WELWYN HATFIELD BOROUGH COUNCIL – DEVELOPMENT MANAGEMENT
DELEGATED REPORT

APPLICATION No: S6/2014/0960/FP

SITE ADDRESS: 45 Bramble Road, Hatfield

DESCRIPTION OF DEVELOPMENT: Erection of two storey side, part two storey and part single storey rear extensions

Scale 1:50 1:100
Date April 2014
Drawn By D. J. BLYTH.
Drawing No: **BD/14/16/2B**

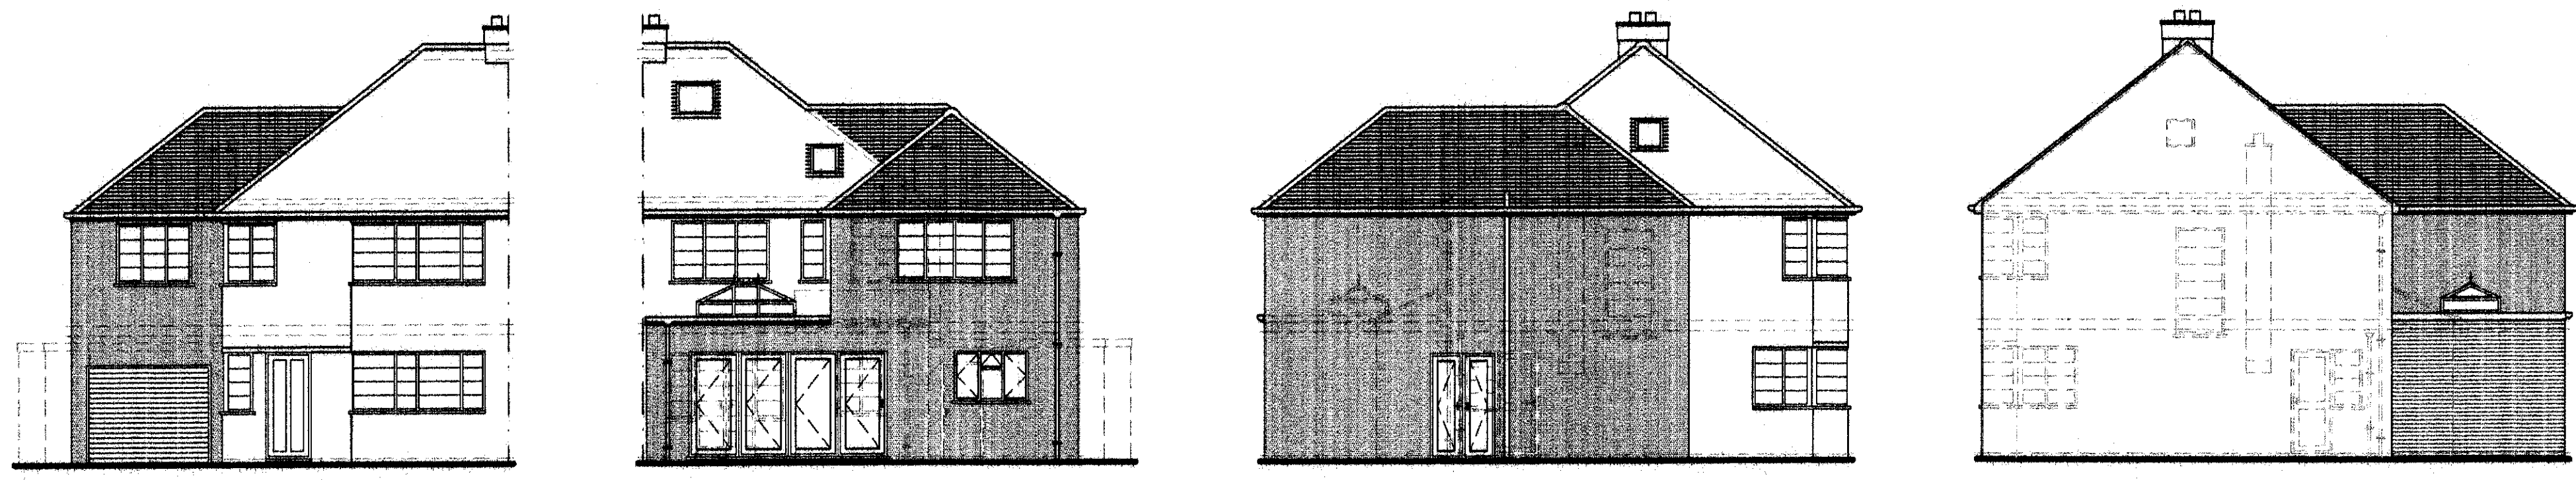
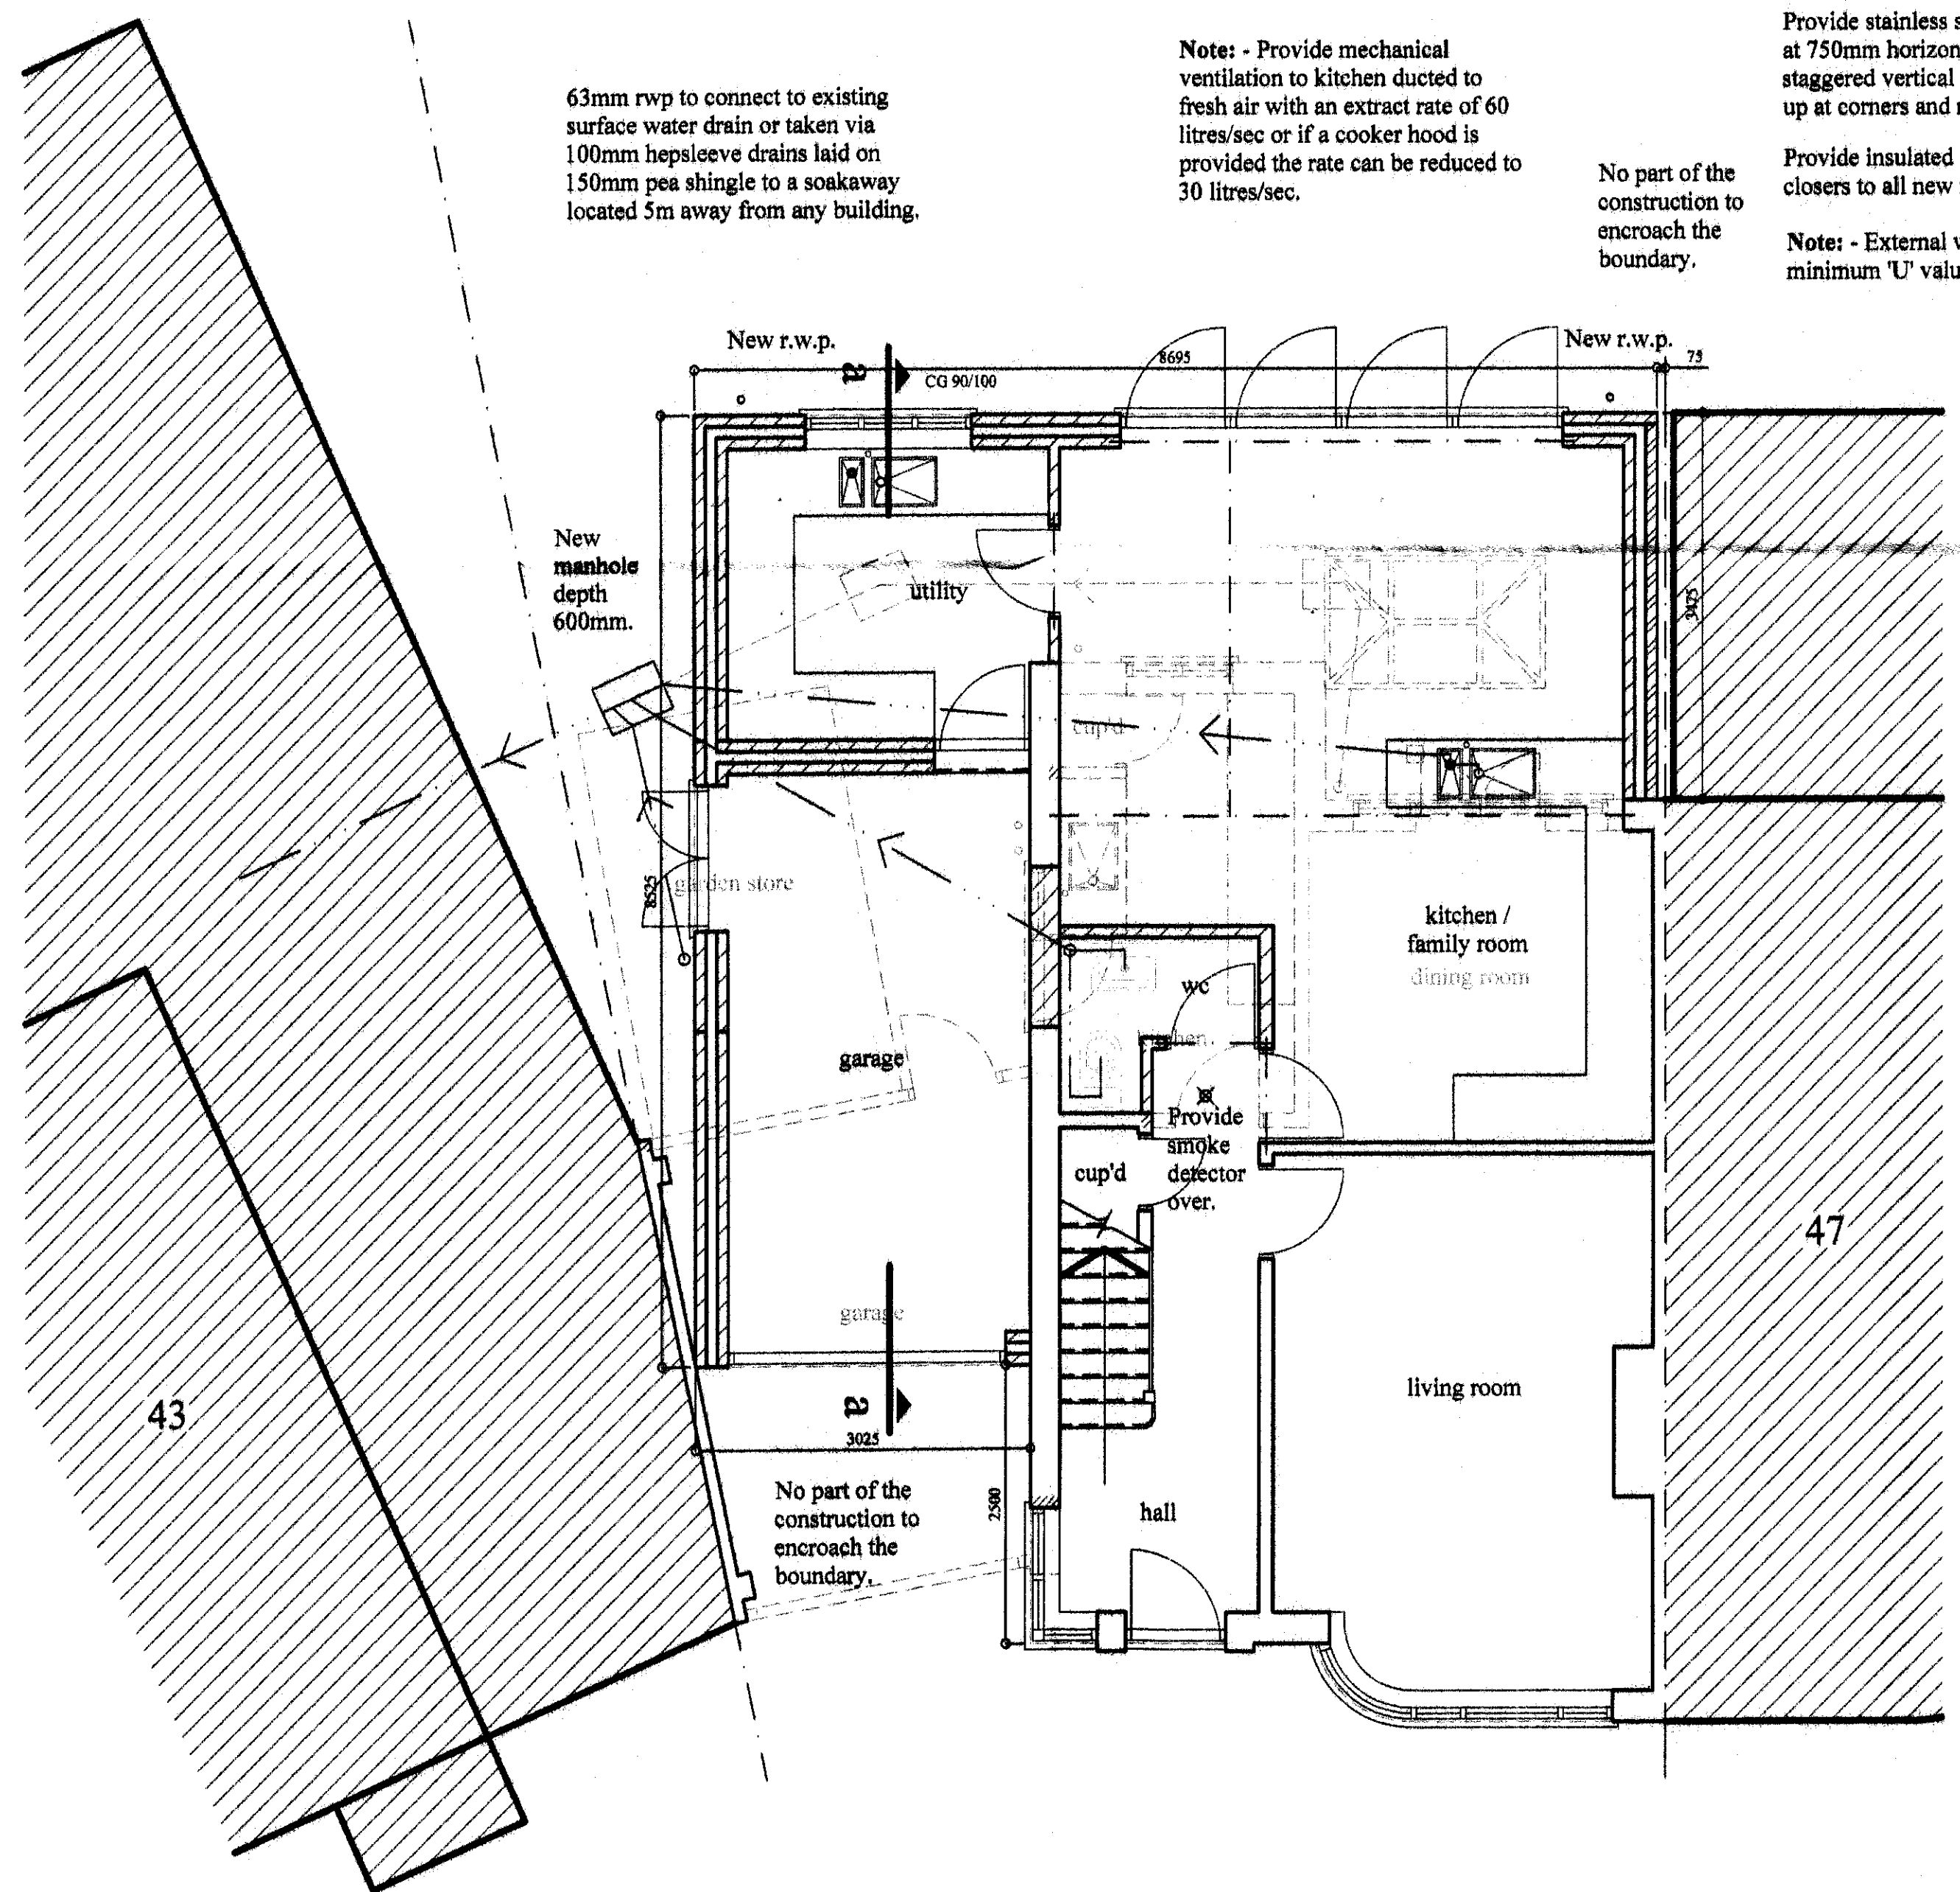
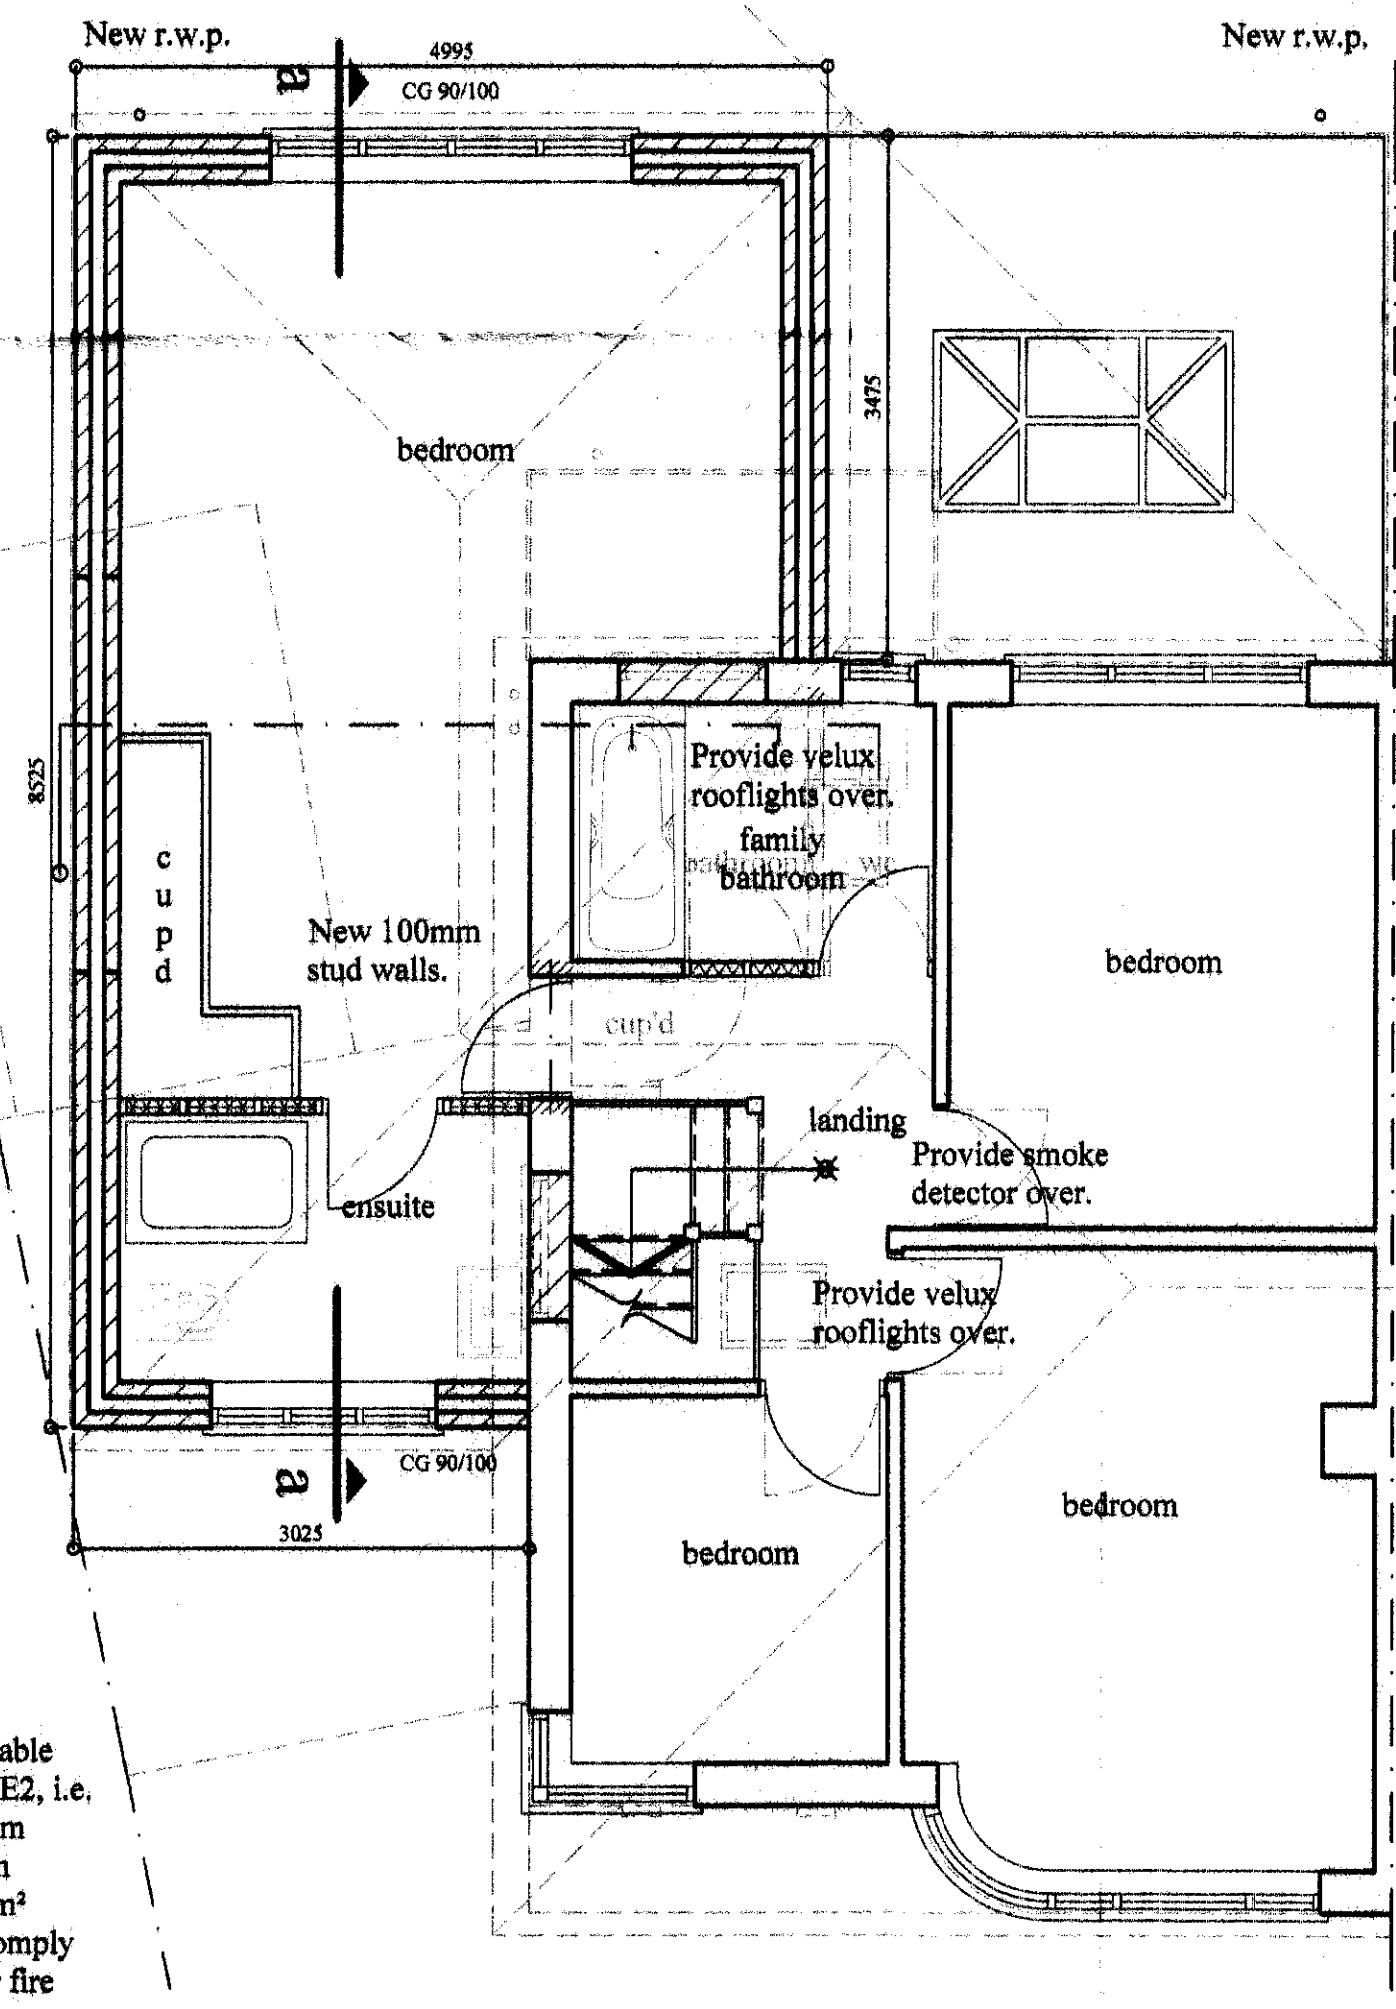
- a) The two storey side extension would have a setback of some 2.5m and the ridge of the roof above the two storey side extension would be set some 1.5m lower than the level of the existing main roof ridge. The side extension would be approximately half the width of the existing house, the extension would be some 3m wide and the existing house is some 5.7m wide. These features would go some way towards making the side extension subordinate in scale to the rest of the house and to ensure that the extension would not reduce the space around the dwelling to such an extent that the resulting dwelling would look cramped on the site. However, it is a longstanding requirement of the Council that two-storey extensions leave a minimum distance of 1m between the extension and the adjacent flank boundary. This spacing is to prevent over development across plot widths and to prevent the creation of a terracing effect.

The proposal fails to be of a high quality design by relating poorly to its surroundings in terms of failing to respect the pattern of built form and open space at first floor level between properties and as such does not maintain or enhance the character and appearance of the property and the surrounding area. It would conflict with Policies D1 and D2 of the District Plan which seek to ensure that development is of a high quality design which respects the character and context of the area. It would also conflict with the Council's SDG which states that 'extensions should be designed to complement and reflect the design and character of the dwelling and be subordinate in scale'. The proposal would also be in conflict with the Framework which at paragraph 17 seeks to secure high quality design.

The extension, by virtue of its scale would fail to reflect the proportions of and be subordinate in scale to the original dwelling. The proposal is to a poor quality of design that would be harmful to the character and appearance of the property.

The extension by virtue of its scale, form and design would fail to reflect the proportions of or be subordinate in scale to the original dwelling. The proposal would result in a visually over dominant addition to the dwelling which would not complement and reflect the design and character of the property and which would be detrimental to the character of the streetscene and wider area. Accordingly the proposal represents a poor standard of design that would be detrimental to the appearance of the property. As such the development would be contrary to policies D1 and D2 of the Welwyn Hatfield District Plan 2005, the Supplementary Design Guidance, Statement of Council Policy 2005 and the National Planning Policy Framework by representing a poor standard of design.
